R/191/21/L

We sent you safe versions of your files; Existing Plans A3.pdf; Hobbs Farmhouse Proposed Plans A3.pdf

R/191/21/HH

R/192/21/L

Drawing: Existing Plans

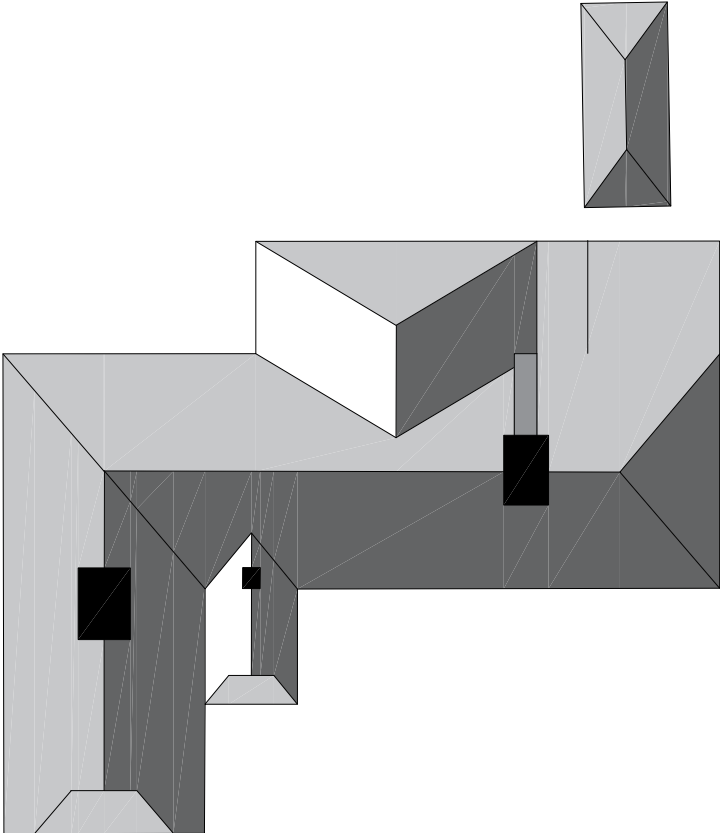
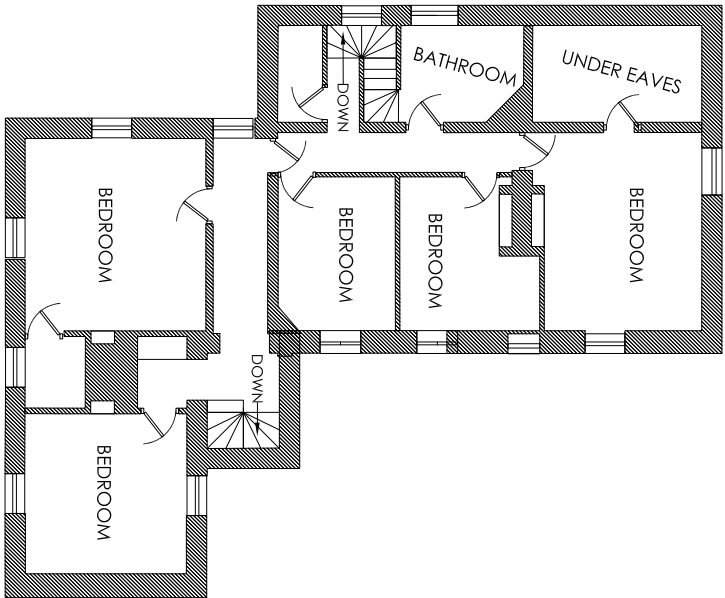
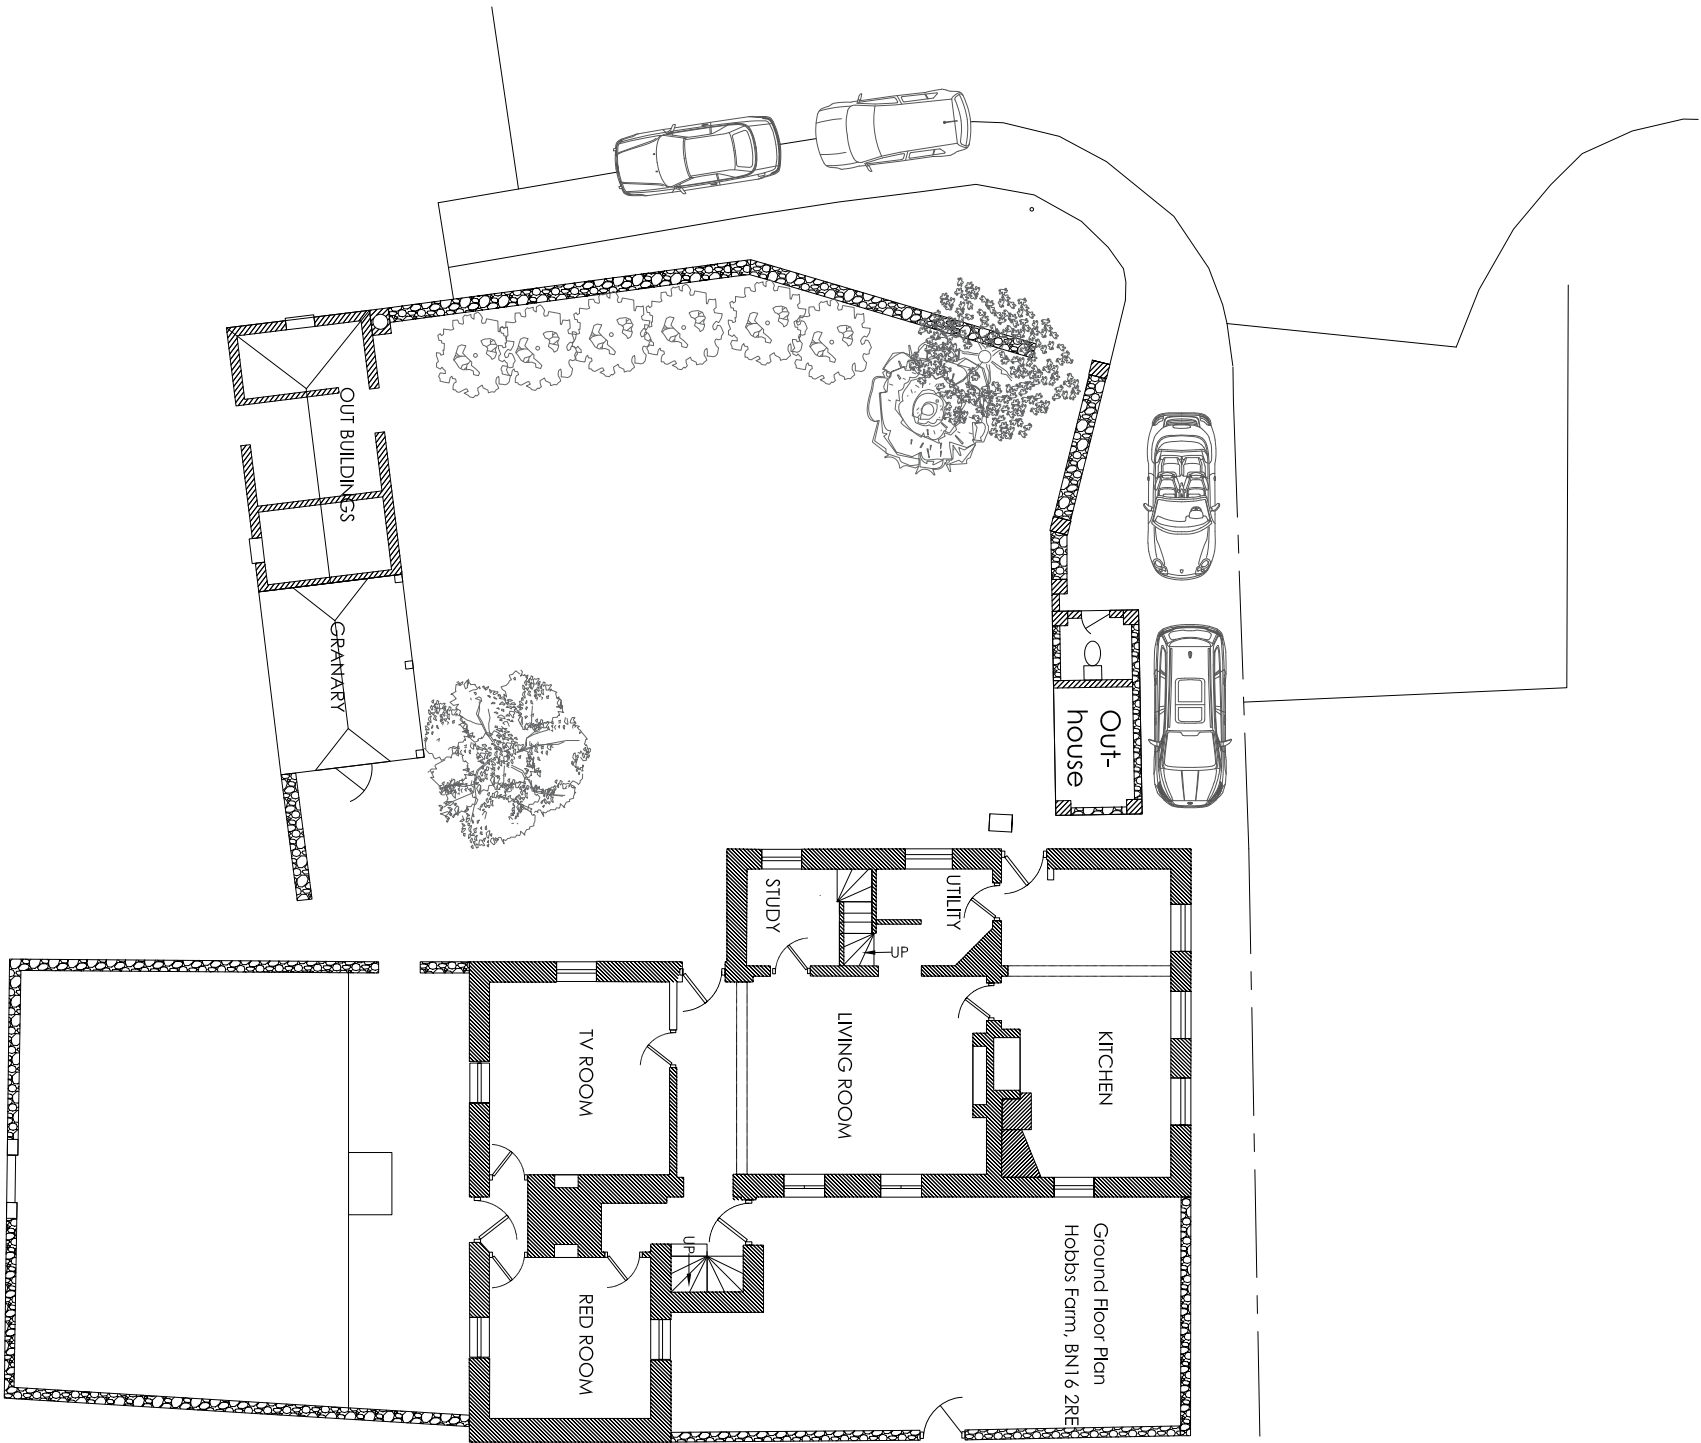
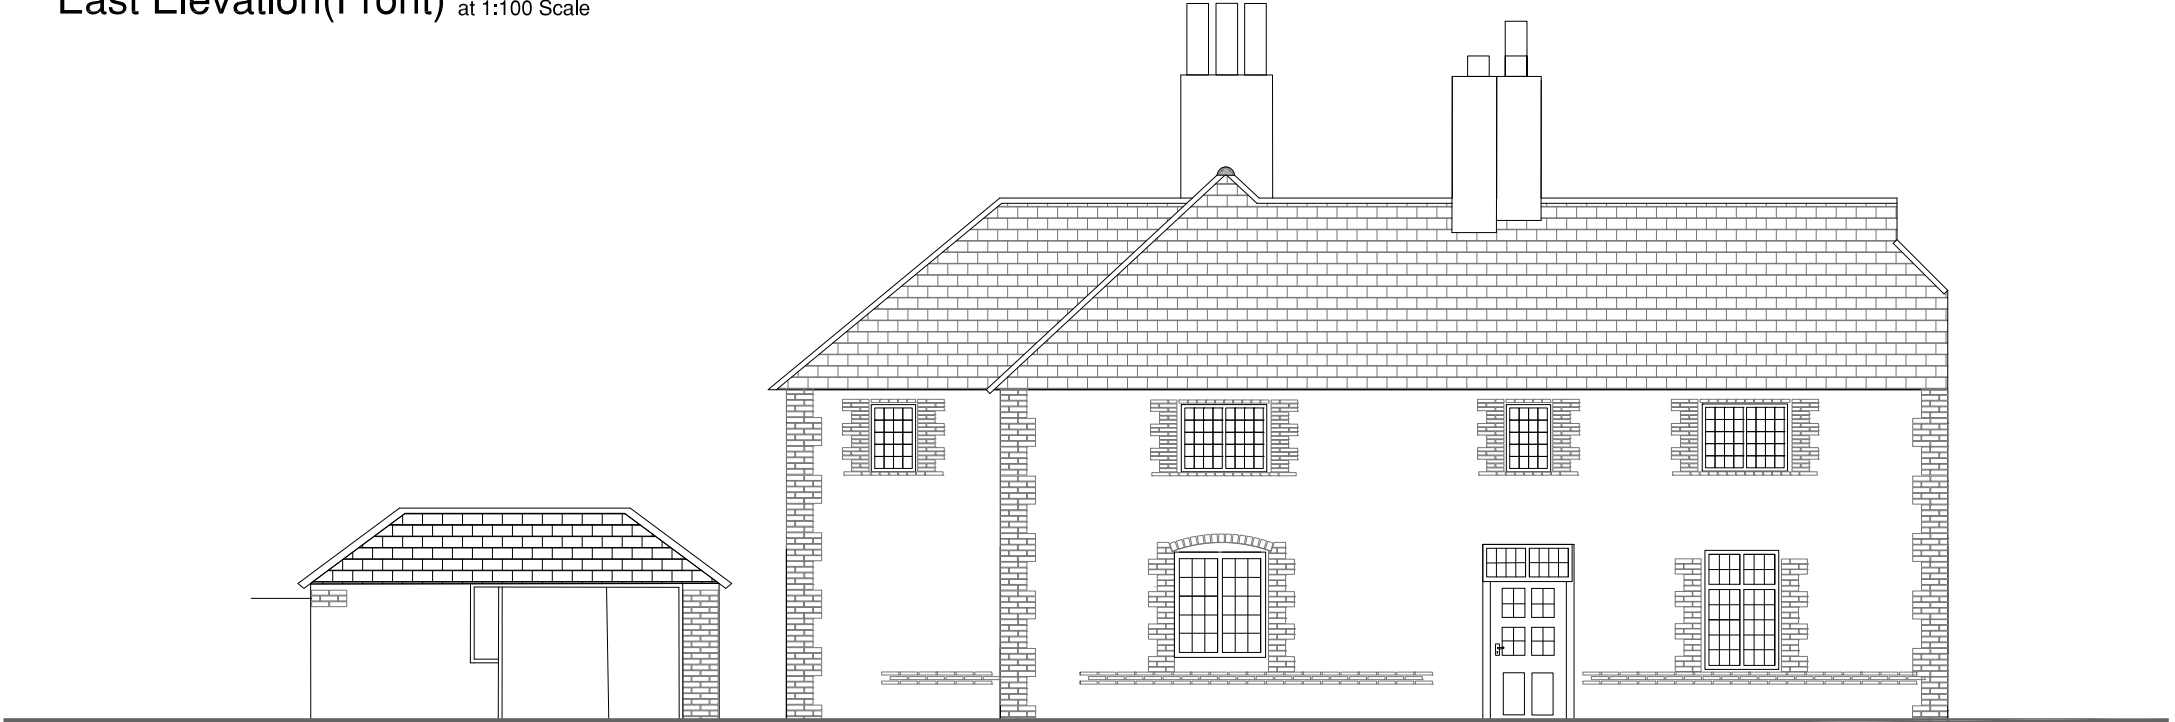
The windows on the existing front and side (south) elevations are inconsistent with the windows on the existing first floor plan. Please review and amend

Added windows on plan to front and side (south) elevation to existing 1st floor plan. 1 No. to stairs (1st floor) front and 1 No. to cupboard on south elevation (1st Floor). Both Existing and proposed plan attached with alteration. As discussed I also added the roof of the outhouse on the 1st floor plan of the existing for clarity.
